Appendix 4-9 - Watercourse Crossings

Laurclavagh Renewable Energy Development

Document Title: Appendix 4-9 - Watercourse Crossings

Culvert Crossing - 33kV - Longitudinal Section
SCALE 1:50

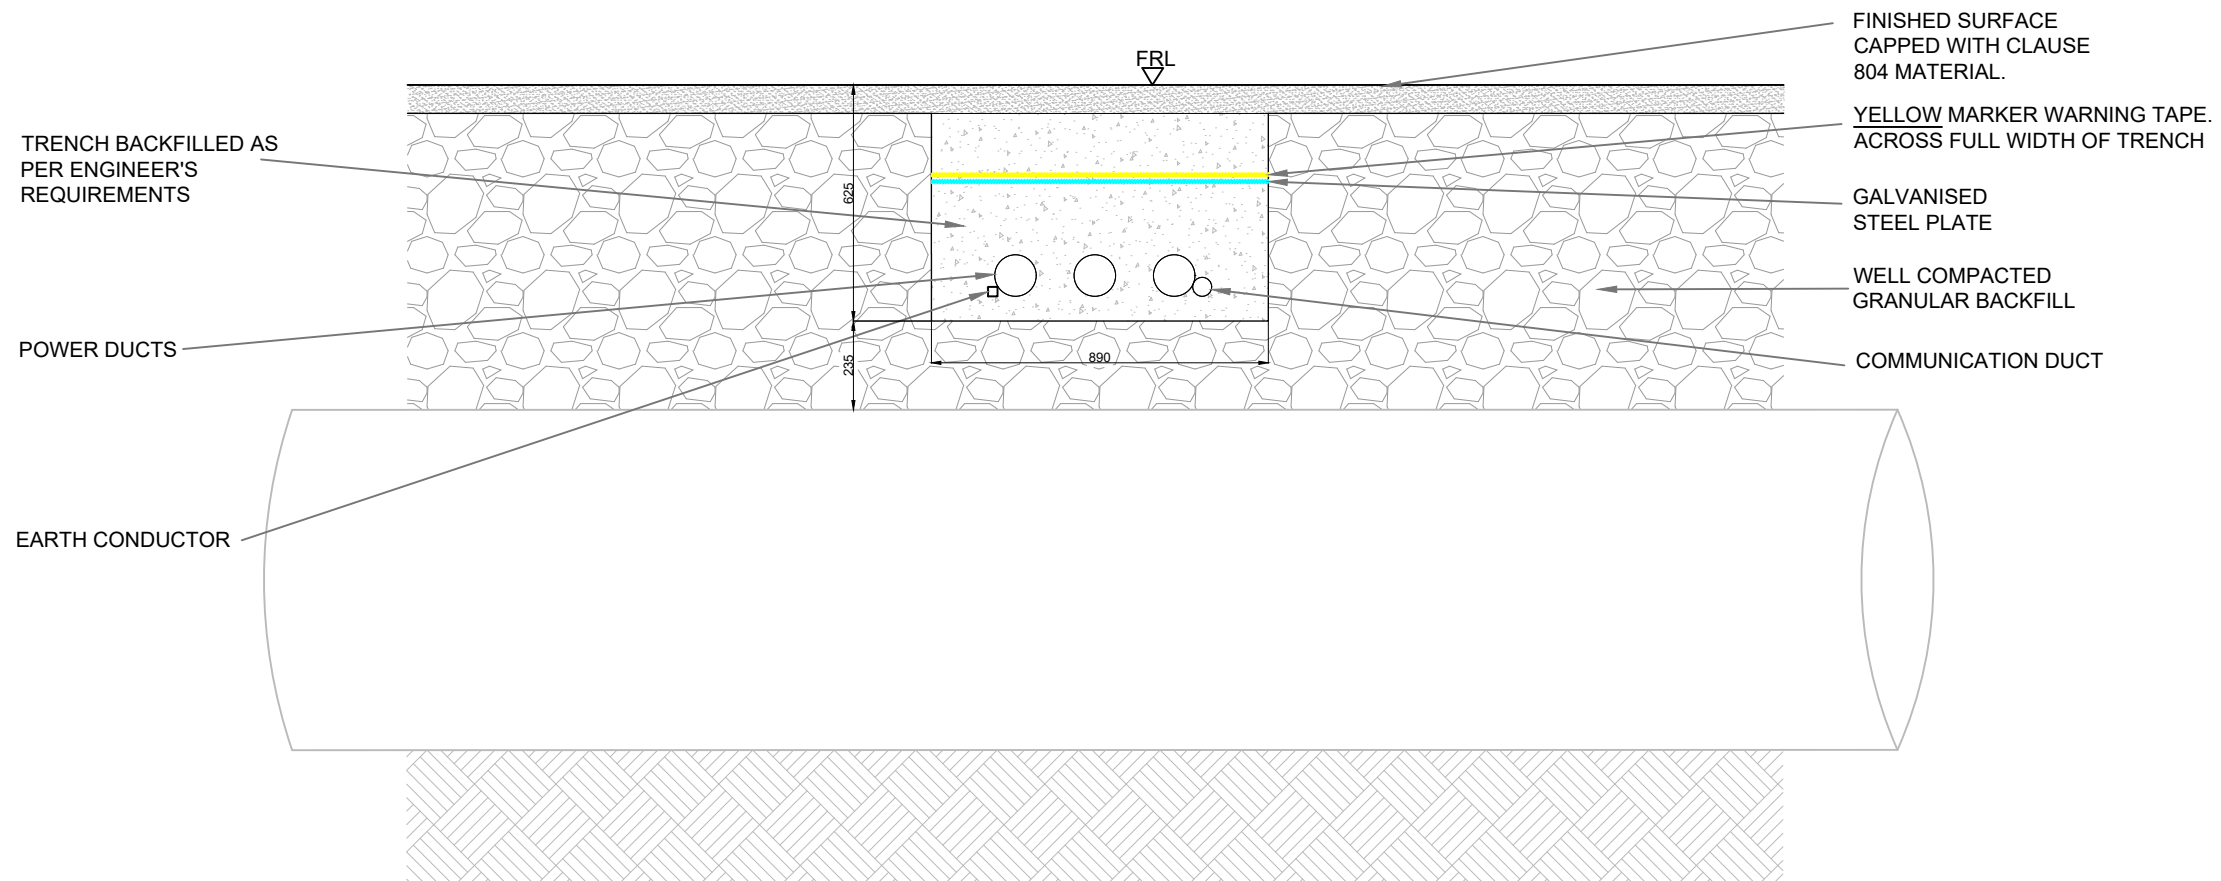
The design methodology for the grid connection crossings in the EIAR is not consistent with that set out in the NIS. The EIAR outlines the River Clare crossing at the site of the Lough Corrib SAC will be via Horizontal Directional Drilling (HDD), with the NIS outlining the River Clare crossing is via an existing bridge crossing. Clarification is sought on the river crossings proposed, and this should be addressed in environmental assessments, where appropriate, and in relevant drawings, sections.

As detailed in Section 4.7.2.9 of the EIAR, a total of 4 no. existing watercourse crossings and 1 no. Motorway crossing will be traversed along the N83 National Road and the L6141 to cater for the Proposed Grid Connection underground cabling route to the existing Cloon 110kV substation. The locations of the watercourse and motorway crossings are shown on Figure 4-27 of the EIAR. Specific details of each crossing are shown in Table 4-4 of the EIAR and reiterated in Table 1 below. Specific Crossing details for all 4 no. watercourses are shown in Appendix 4-8a of the EIAR Addendum, Grid Connection Infrastructure, and in Figure 2, Figure 4, Figure 6 and Figure 8. The watercourse crossing methodology for each location is set out below. In stream works are not required at any watercourse crossing along the Proposed Grid Connection underground cabling route.
